From: Paul Freeman
To: Daniel Howard
Date: 19/10/2010 4:54 PM
Subject: Fwd: Online Submission from Janet Murray (object)

RE: P 07_0087 EXTENSION OF THE PROJECT APPROVAL AREA FOR OUT-OF-PIT OVERBURDEN EMPLACEMENT AND REHABILITATION, ALTERNATIVE HAUL ROAD AND POWERLINE RELOCATION

Submission for Job: #3662 Bloomfield Coal Project - Mod 1

Figure 8: Predicted annual average PM₁₀ concentration for Stage 2 – Bloomfield Colliery and other sources

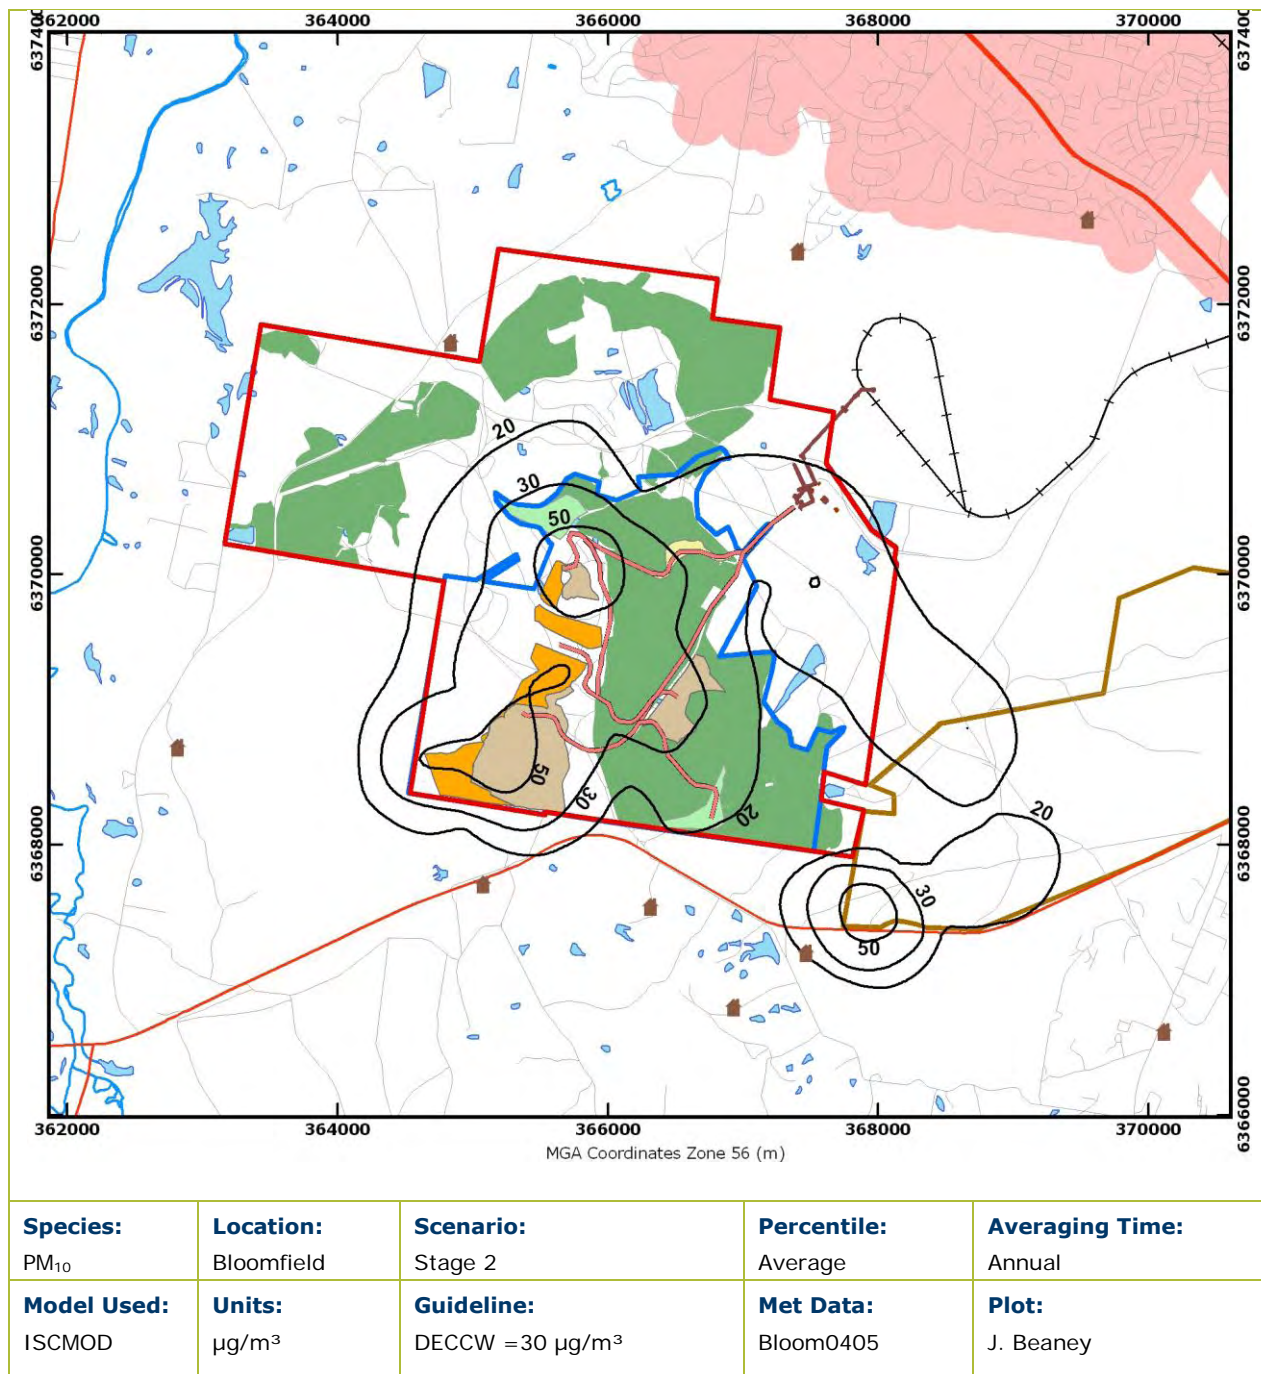
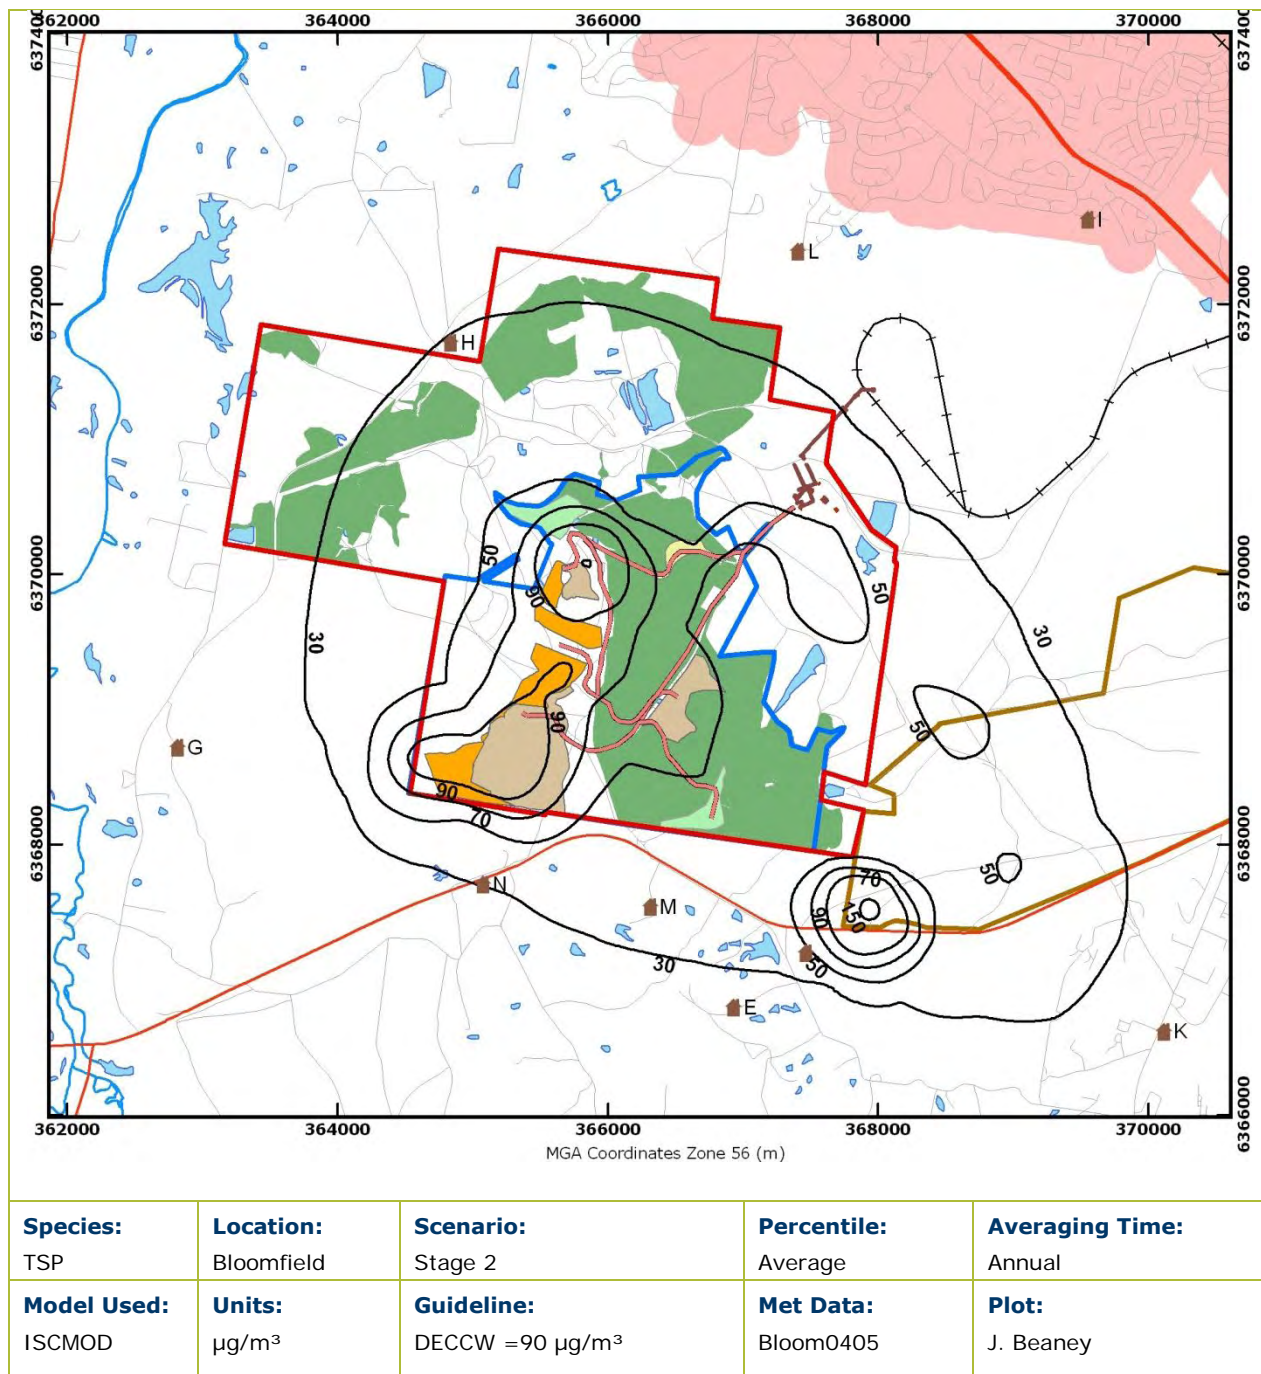
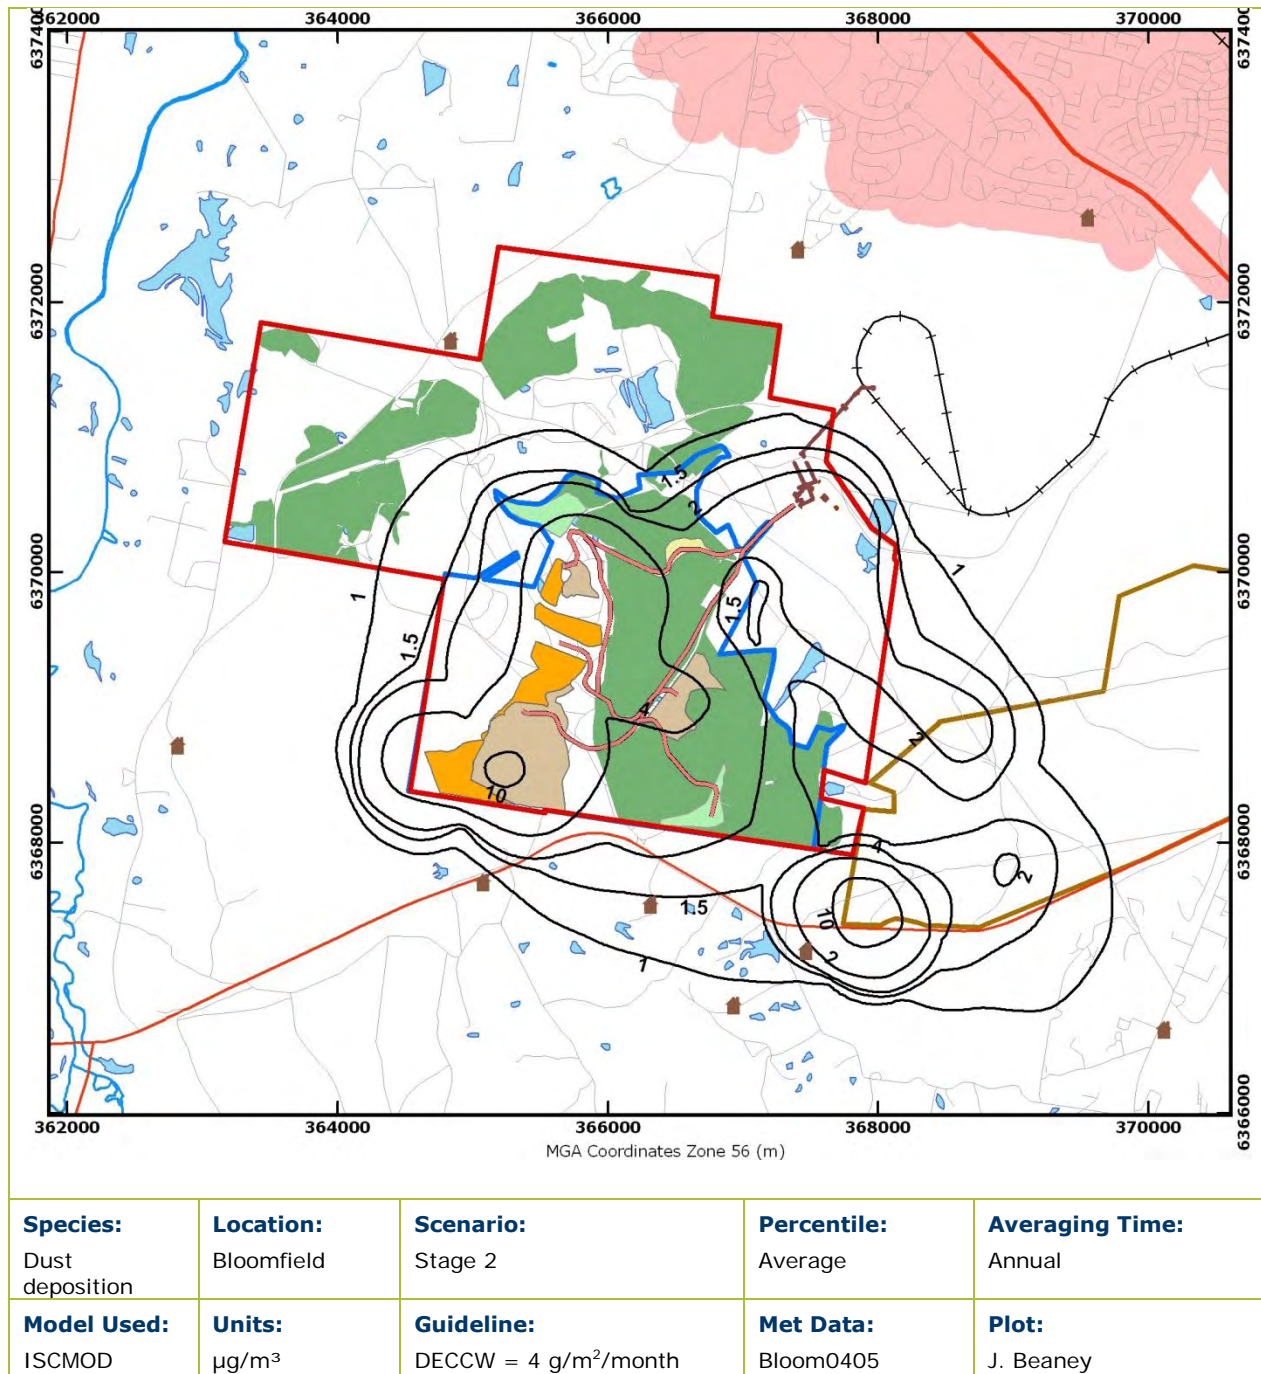
 Figures 8-10 in the Air Quality Assessment, looking at the impact of Bloomfield Colliery and other sources all show a ?hotspot? of increased concentrations inside the Donaldson boundary to the north-east of residence F. While the concentrations at residence F do not exceed the impact assessment criteria, one can?t help but wonder whether they are exceeded over 25% of that privately owned land on which residence F sits (as required by Consent condition 15)? It is also unclear to me what emissions and values have been included in the cumulative assessment, as the letter from PAE Holmes says ?Emissions from these common facilities have only been included in the cumulative assessment. It was assumed that annual average concentrations due to emissions from distant mines and other sources, including the shared CHPP are? These data are consistent with values used in recent assessments?.
